NEATH PORT TALBOT COUNTY BOROUGH COUNCIL

WRITTEN REPRESENTATIONS

Power Generation Enhancement scheme at
Port Talbot Steel Works, Margam.

PINS REFERENCE: EN010062

### 2.06 Indicative Elevations, Sections & Floorplans

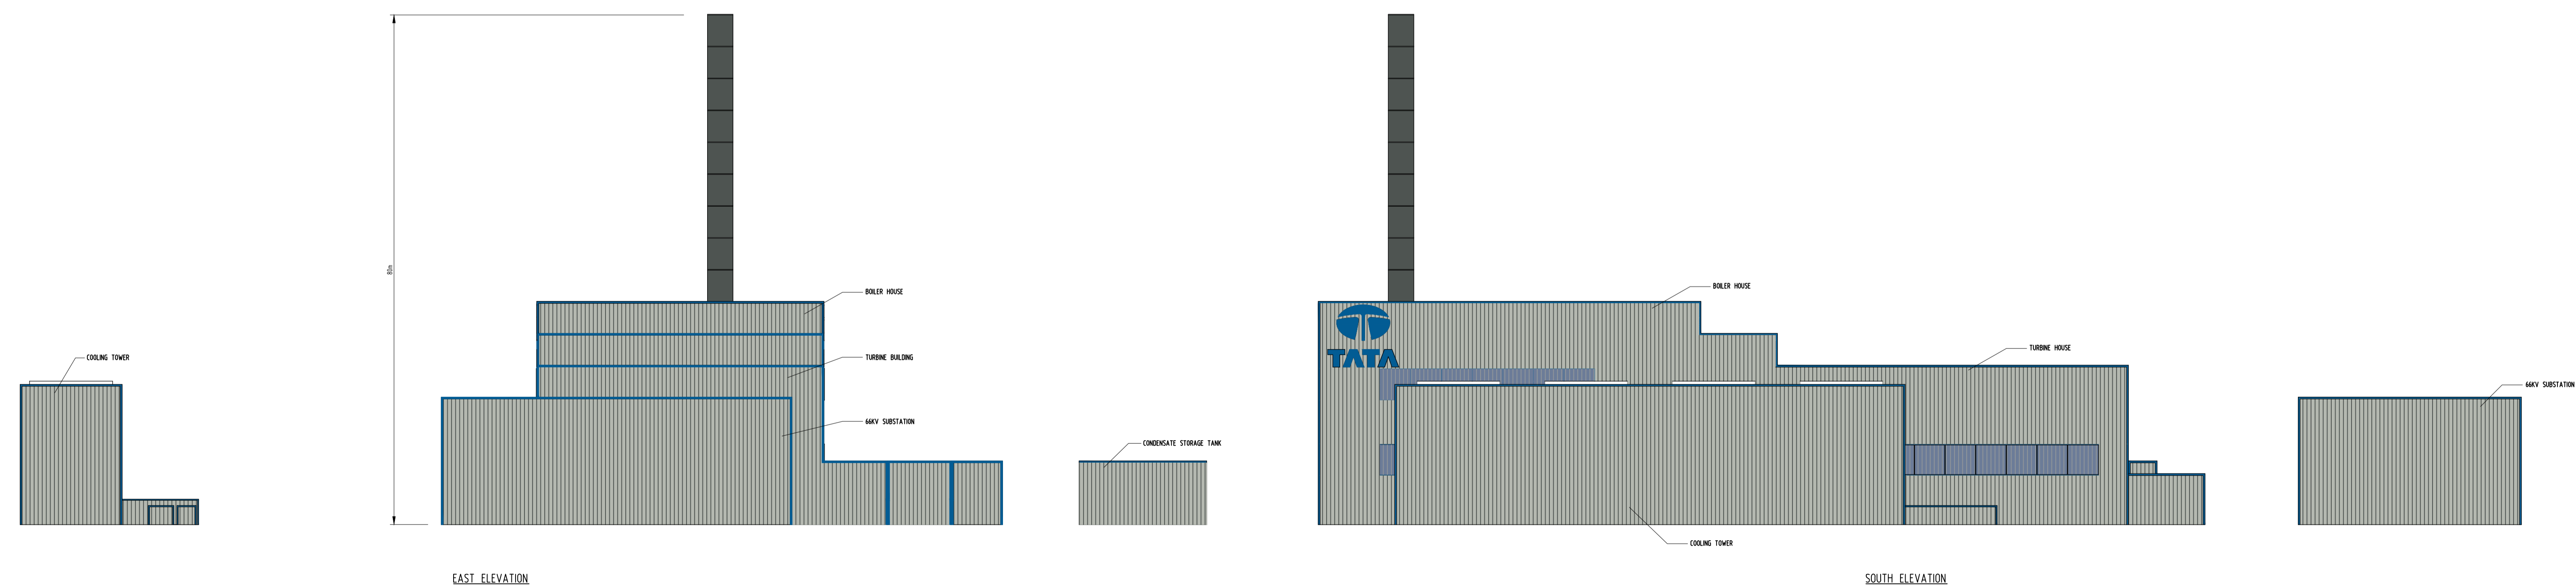
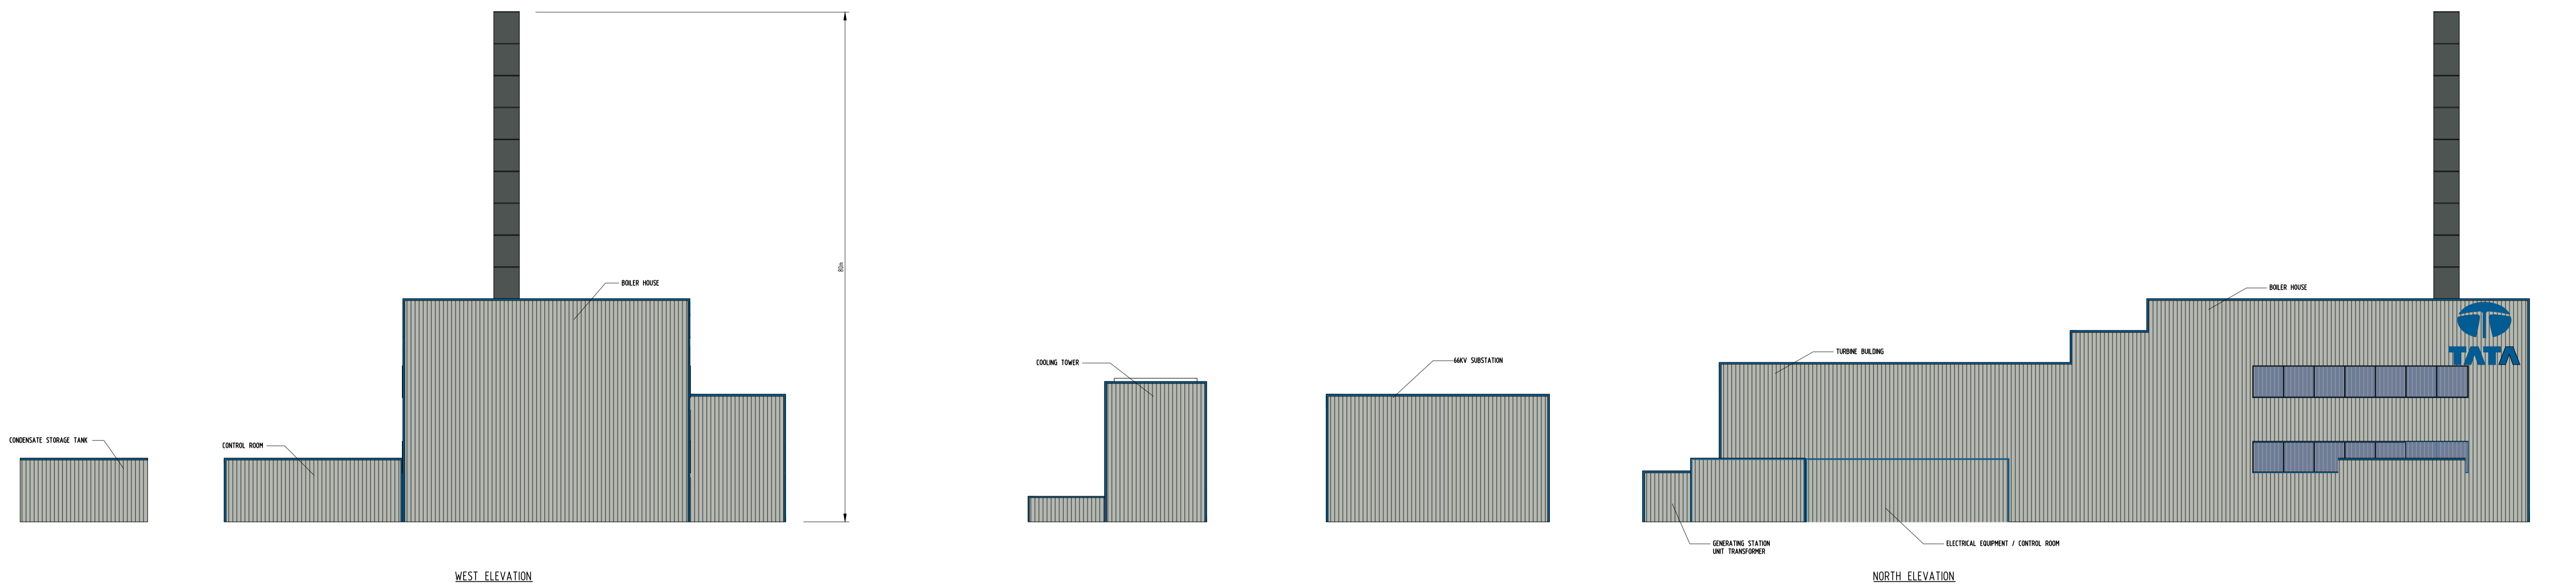
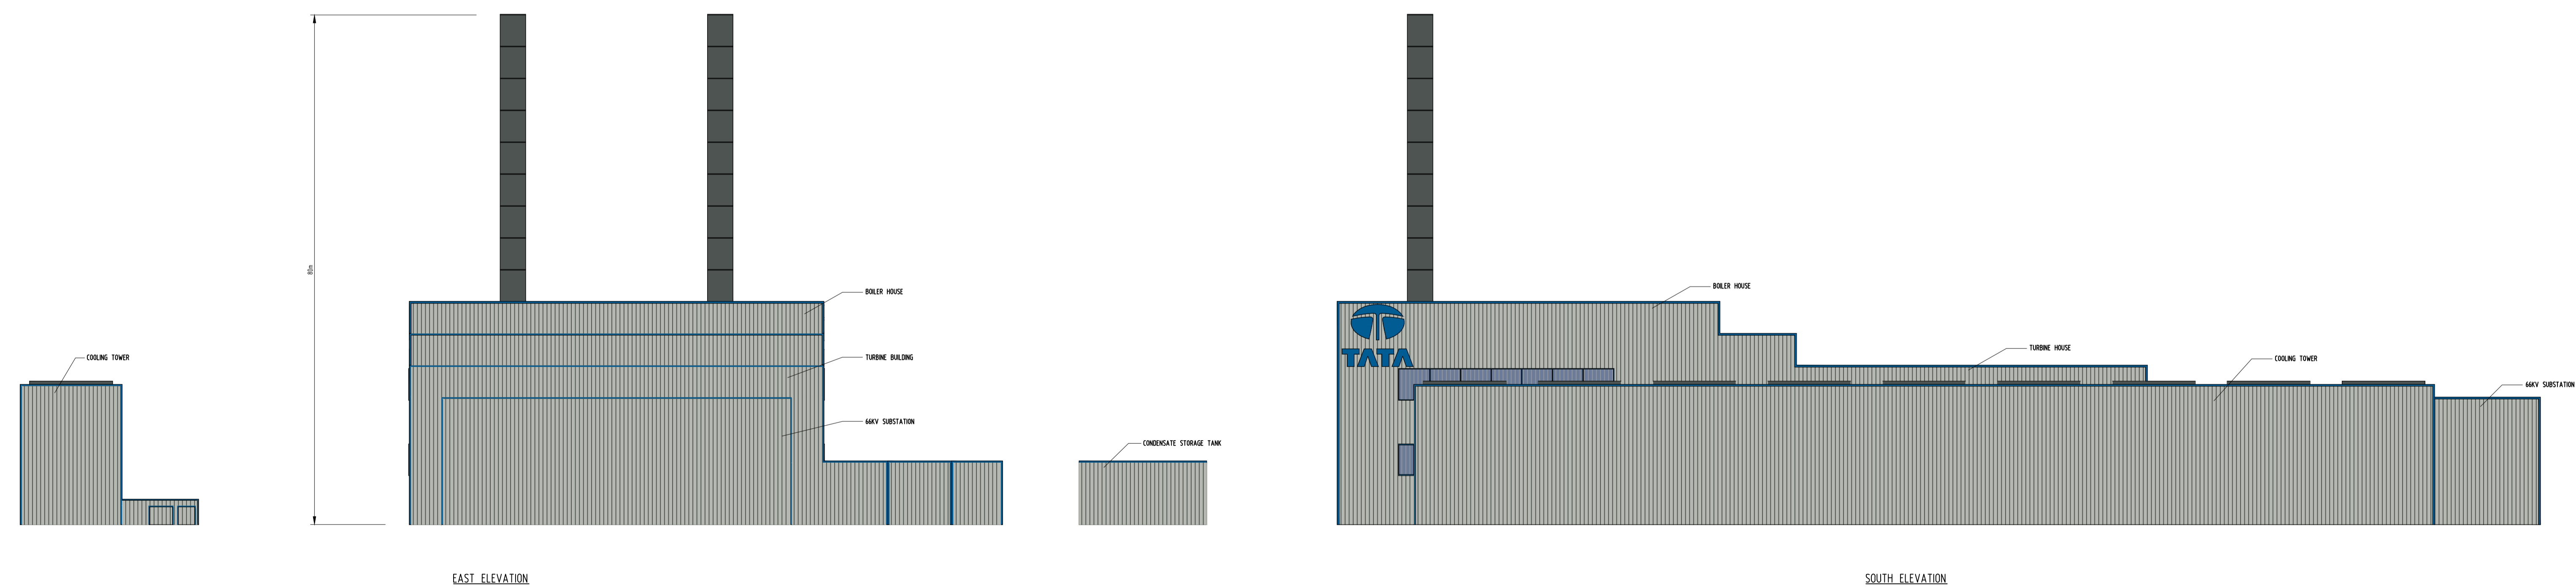
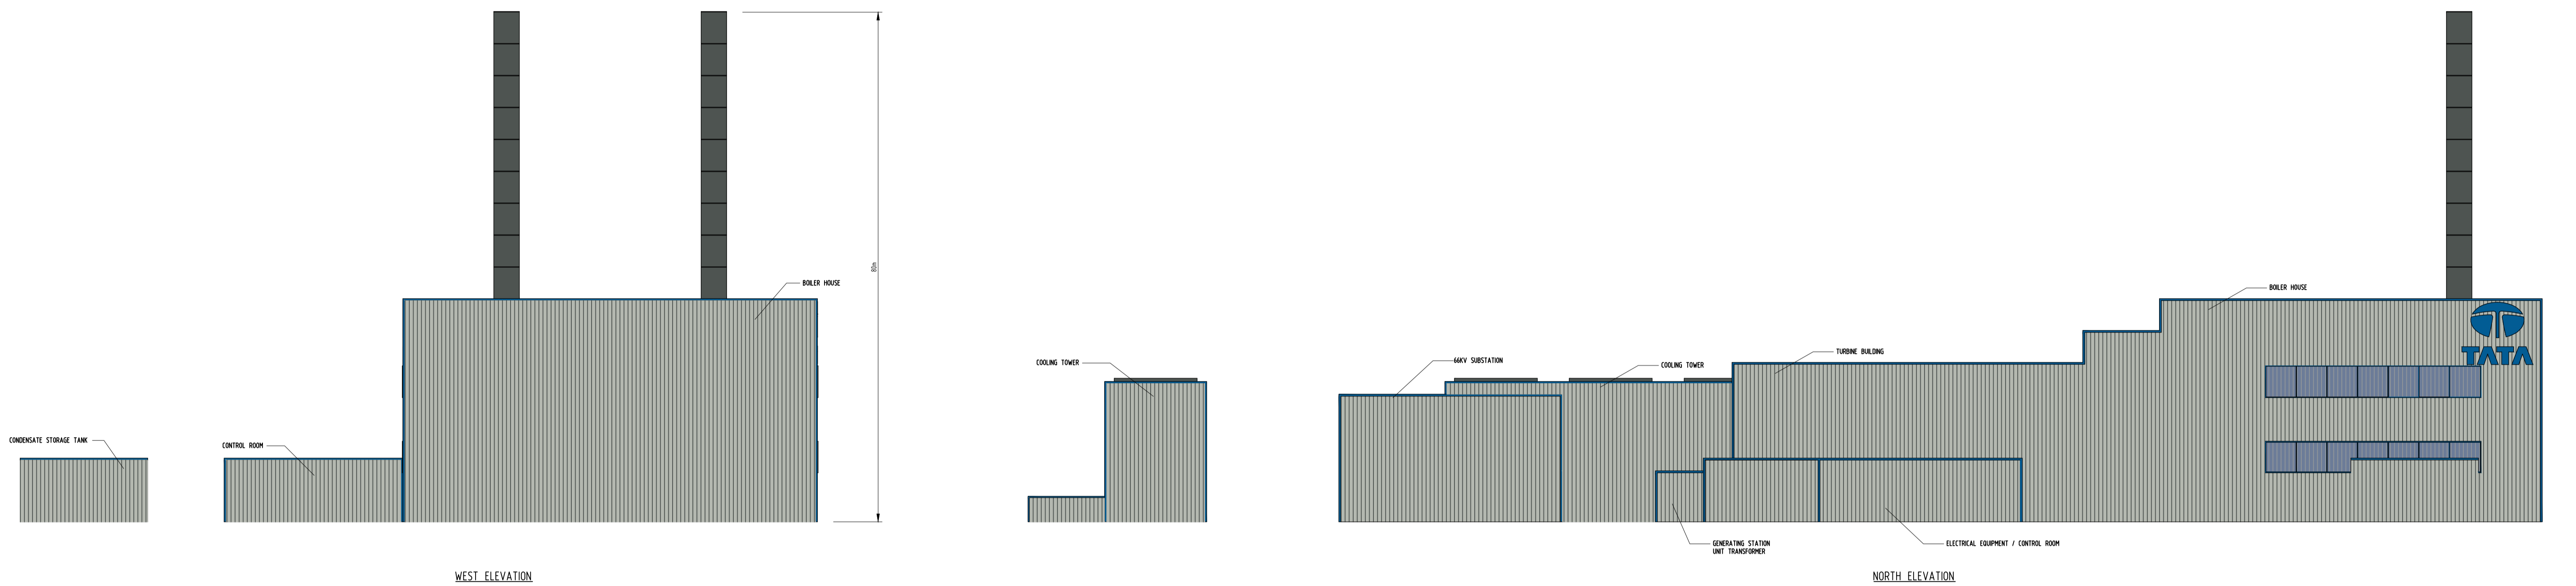
4. In this regard, the Council is concerned that the illustrative drawings and photomontages submitted with this application to date do not demonstrate the clarity of design thought expected for a scheme of such magnitude, with such potential for significant landscape and visual impact, or reflect the acknowledged recognition in the ES that good design of the buildings associated with the development is an essential requirement.

5. Accordingly, providing extensive and detailed consideration is given to a scheme of the highest quality in terms of design, use of materials and landscaping, (whether as two distinct phases or a single proposal), and that the applicant is able to demonstrate that commitment through additional submissions, it is considered that the proposed development would be unlikely to result in any significant detrimental impact in terms of visual amenity and has the potential to become a key landmark building which could enhance the appearance of this area of Port Talbot.
